**Final Acceptance Punchlist**  
**El Paso County – Department of Public Works - Stormwater Section**

Project Name:	The Gardens at North Carefree
EDARP Filing Number(s):	SF195, CON2012
ESQCP Number:	ESQ1912
Attendees:	DPW SW: Dylan Finley, Mikayla Hartford, Ben Jones DPW Development Services: Brad Walters, Joe Jackman, Spencer Pirzadeh, David Parkerson Developer: Grace Covington
Date of Walk-Thru:	02/01/2024
Walk-Thru Number:	1 <sup>st</sup>

Findings to be addressed prior to scheduling a follow-up walk-thru:

**SHEET 24 OF 34**

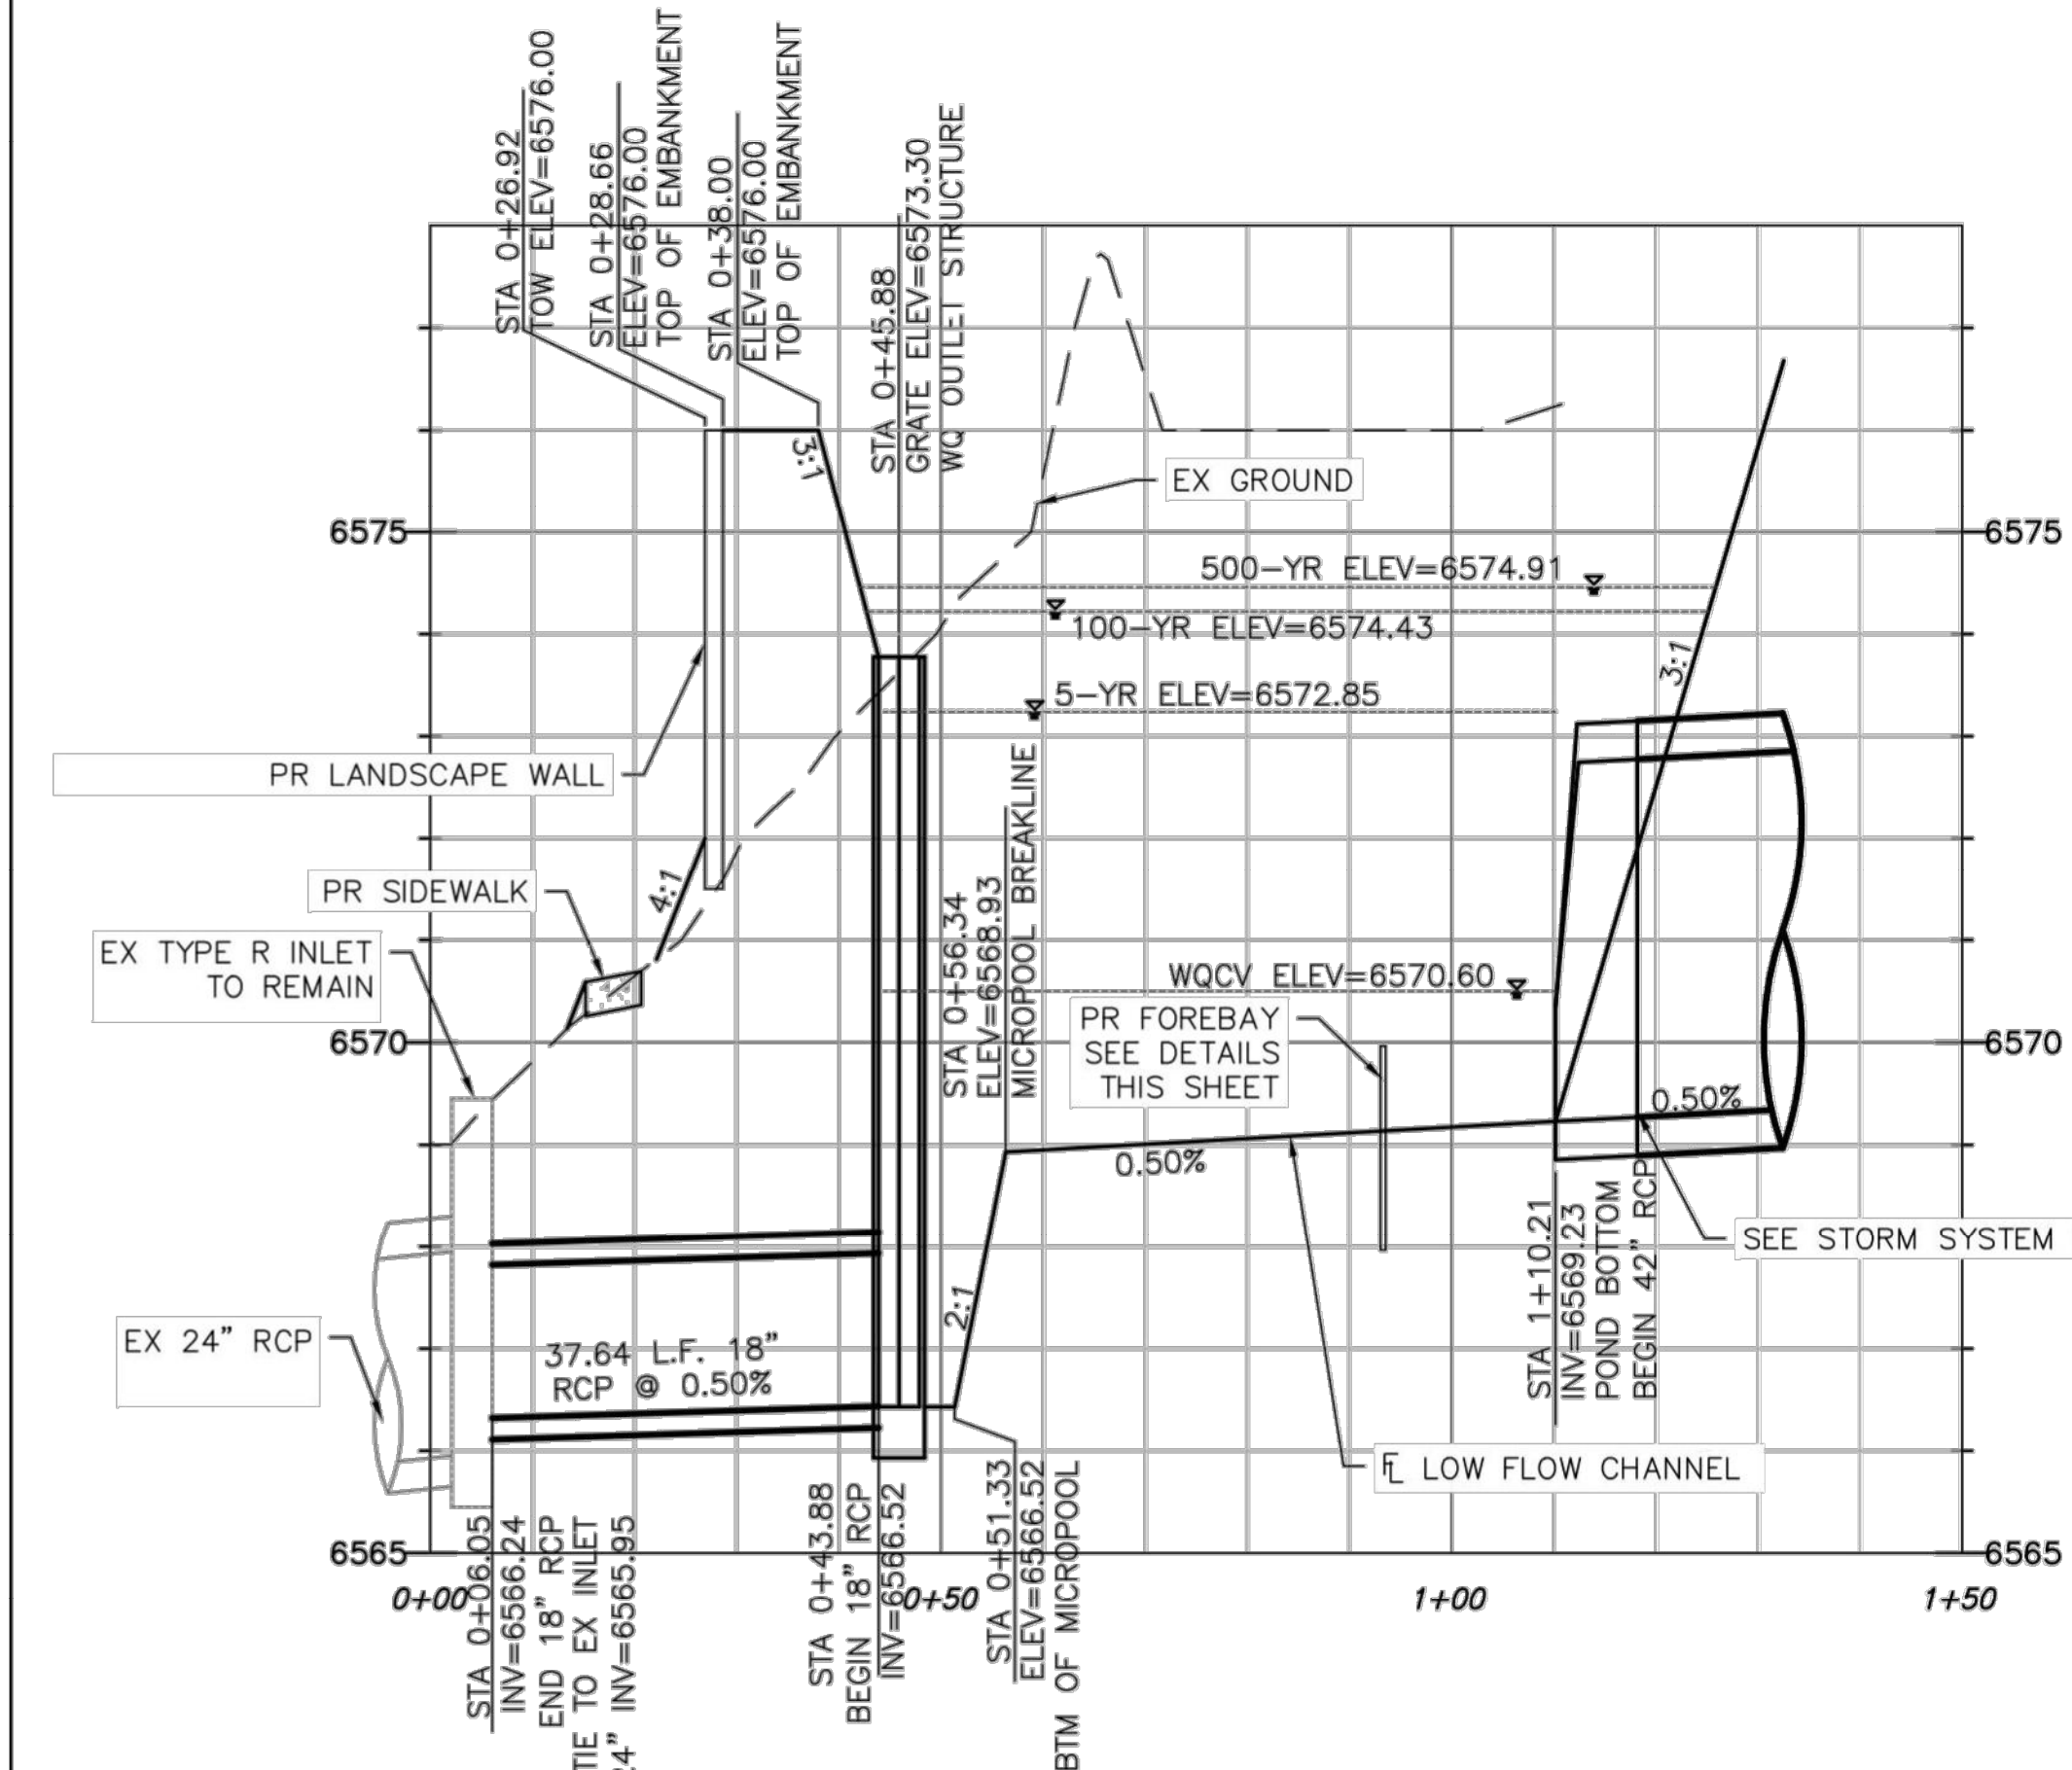
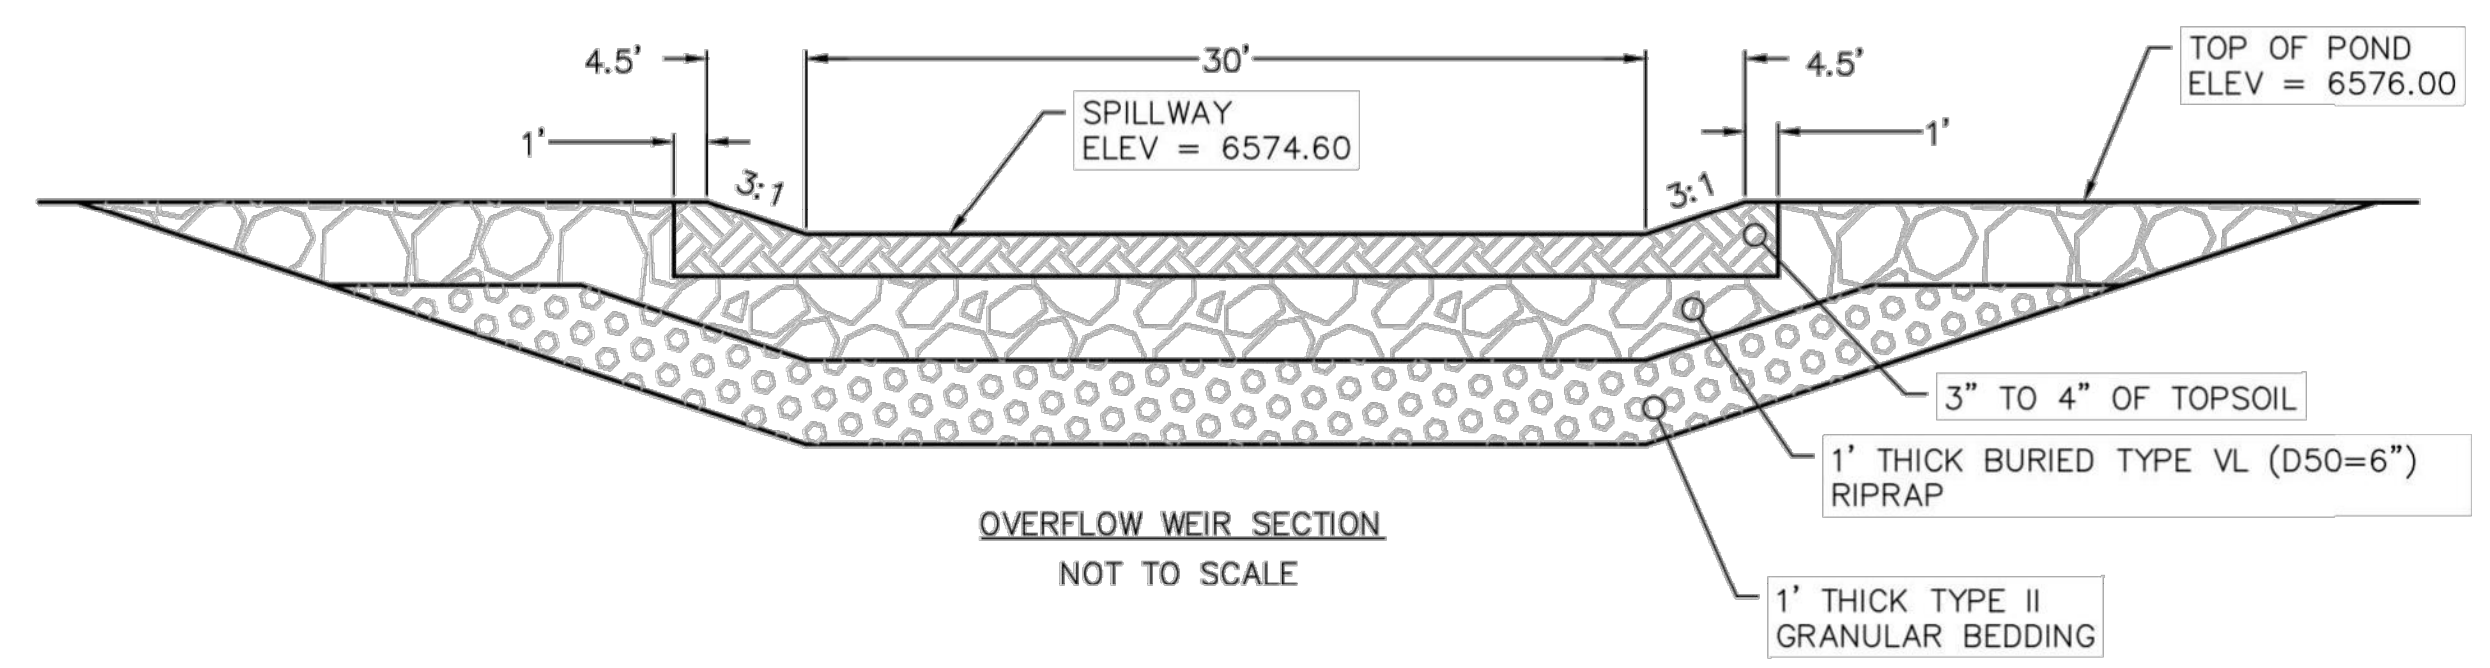
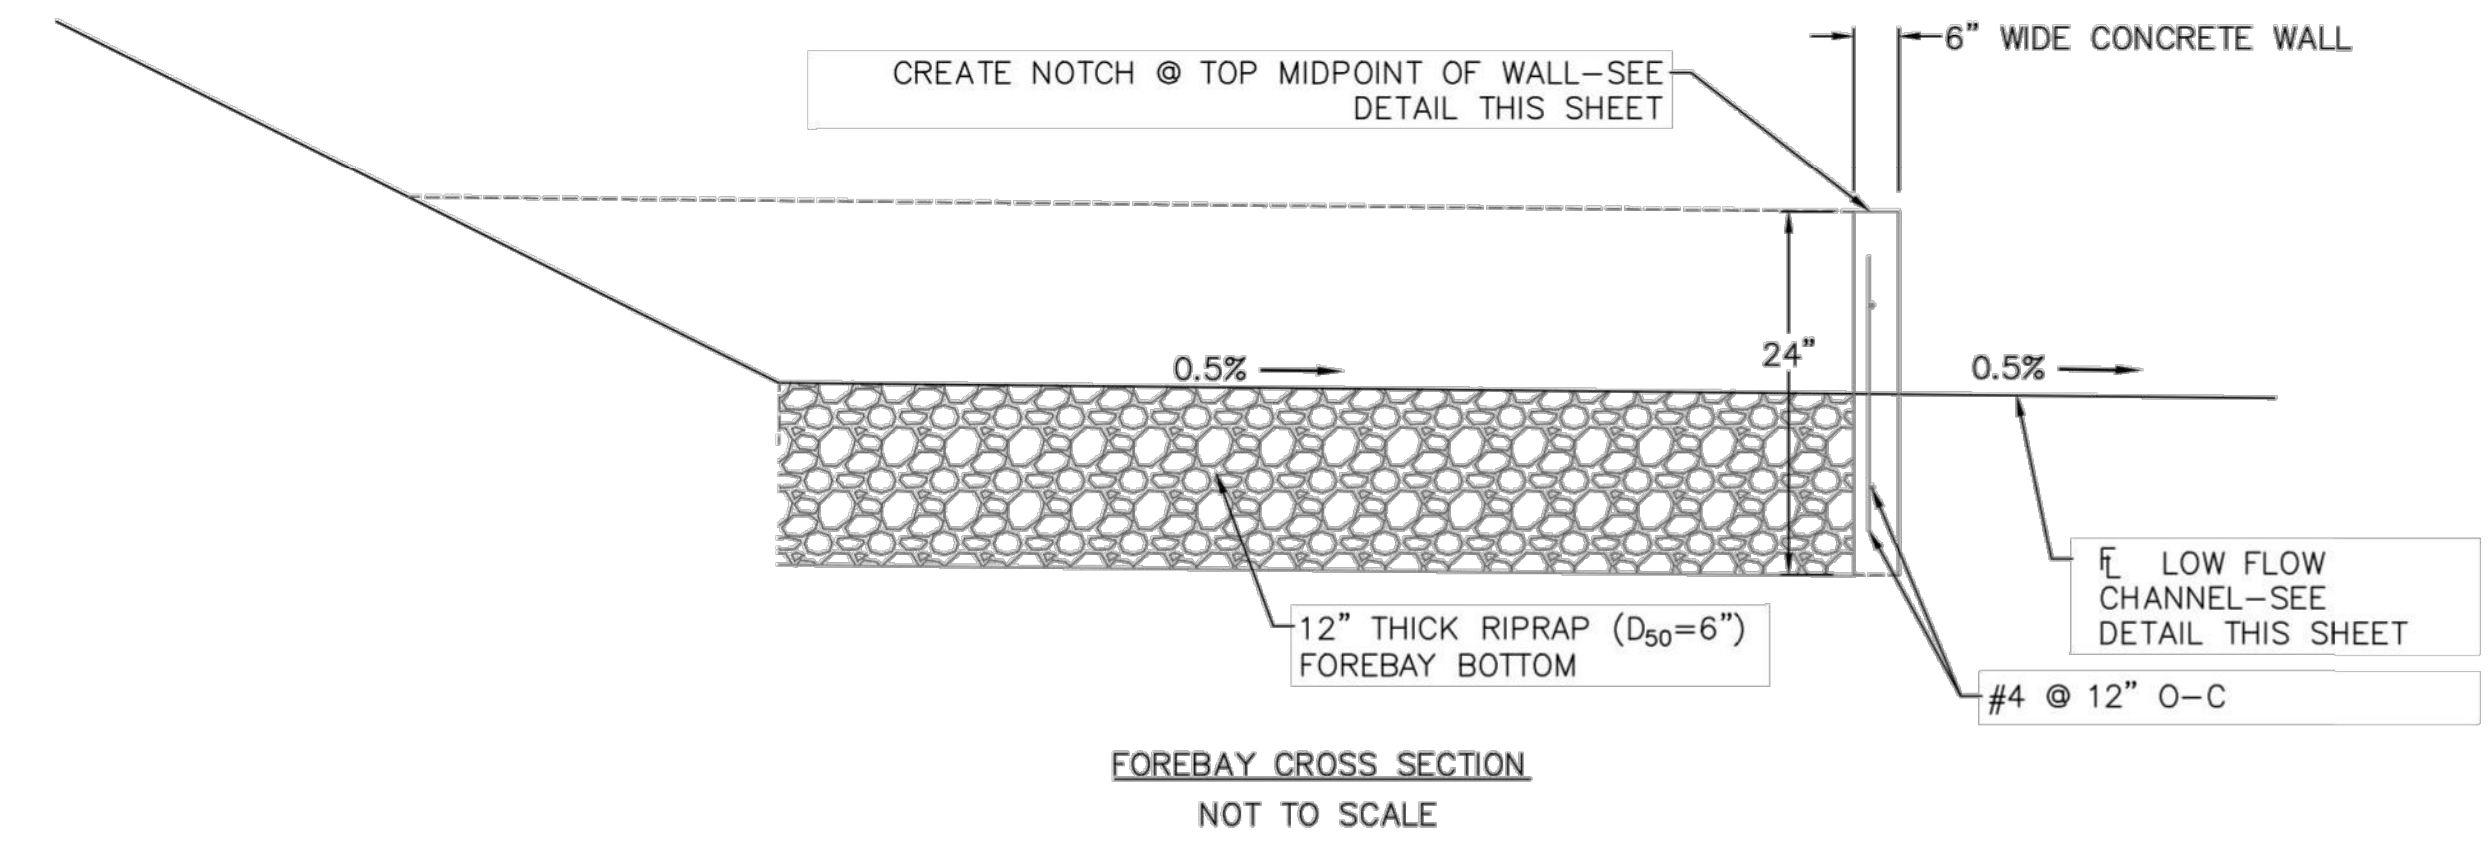
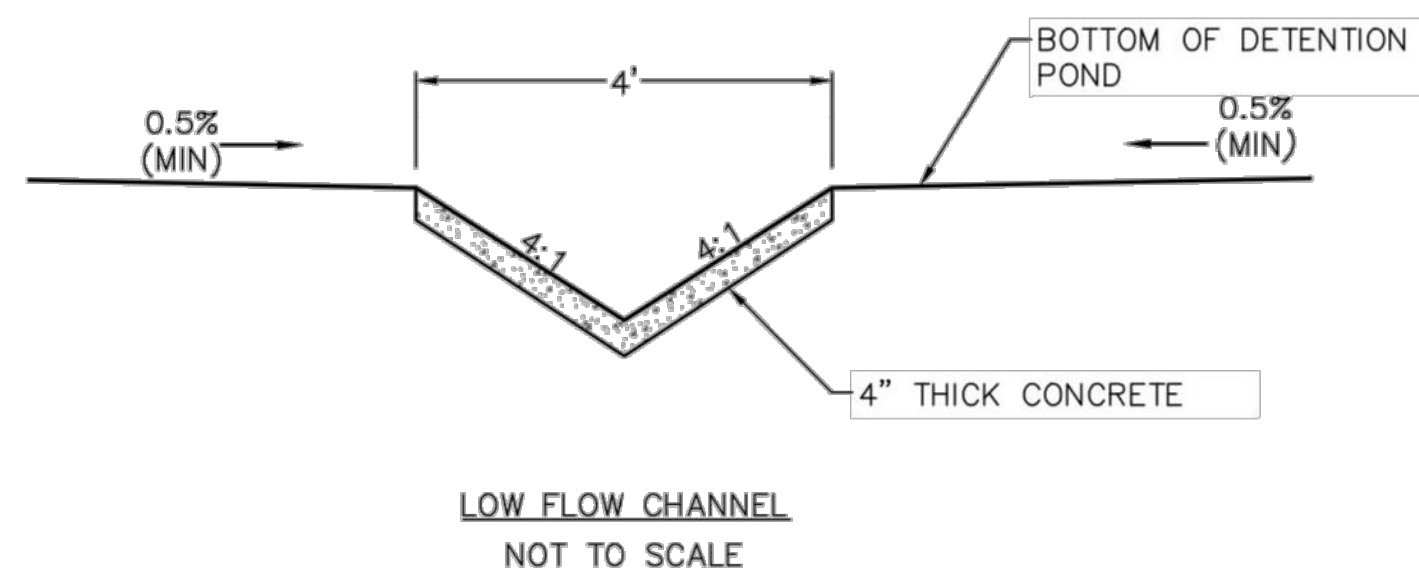
- **North Pond: (Page 24 of Construction Drawings)**
  - Pond forebay not installed per forebay cross section detail. Re-establish to pond details. Riprap to be installed per plan with a 12” drop between the top of the forebay curb and the riprap.

- Maintenance road not installed per plan. Re-establish per pond detail, maintenance path to be 12-foot wide and extending to the pond bottom.
  - Orifice plate caulking missing. Re-establish caulking to create a watertight seal.

- North embankment requires stabilization.
- **South Pond**
  - Pond forebay not installed per forebay cross section detail. Riprap to be installed per plan with a 6” drop between the top of the forebay curb and the riprap.

Photo 1: North pond forebay not installed per spec. (Page 24 Forebay cross section)

Photo 2: North pond maintenance road not installed per spec. ( 12' wide with 2" rock and extends to forebay)

Photo 6: Stabilize northern pond embankment at north pond.

Photo 7: Re caulk orifice plate at outlet structure.
